**SUBMISSION TO THE DEPARTMENT OF PLANNING AND INFRASTRUCTURE ON THE PROPOSED  
NORTH WEST RAIL LINK (NWRL)**

**Application Number: SSI-5100**

Figure 6.11 Cheltenham Services Facility light vehicle access and egress

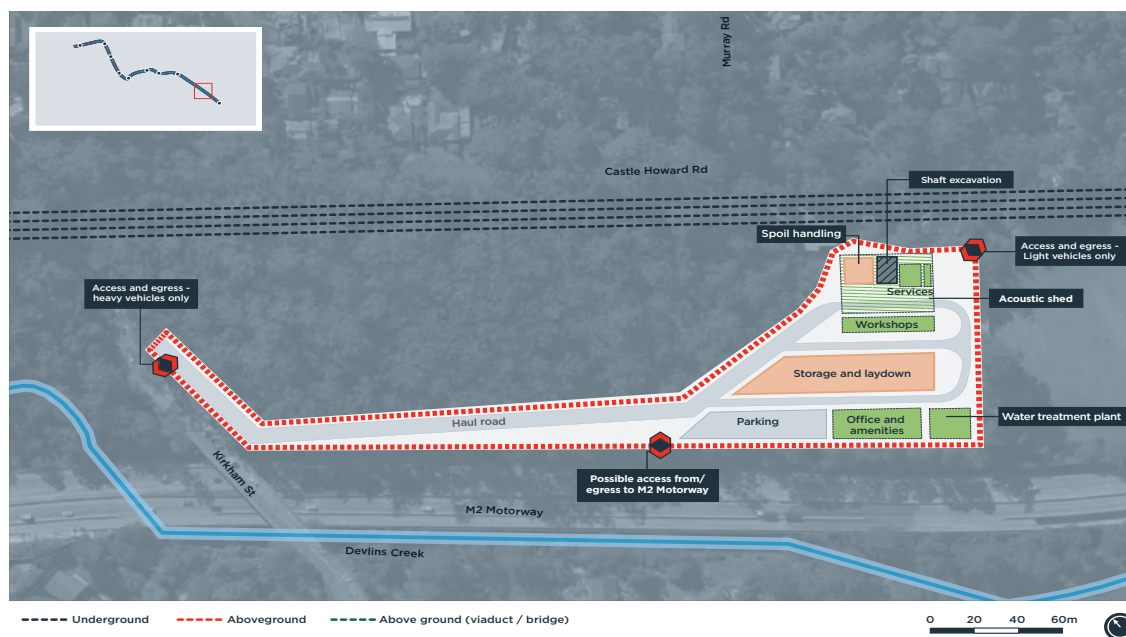
1. The option to construct a new two lane paved road through the Castle Howard Conservation Reserve to Kirkham Street (or Castle Howard Road) near the bridge over the M2 to allow trucks to remove spoil during construction and light vehicle access during operation of the facility will permanently destroy valuable Blackbutt Gully forest.

5. Should the roadway be built, the local streets (Kirkham Street, Castle Howard Road, Murray Farm Road and the bridge over the M2) are narrow, winding and congested and would not be suitable for trucks and, in the event of an emergency, large numbers of emergency vehicles.
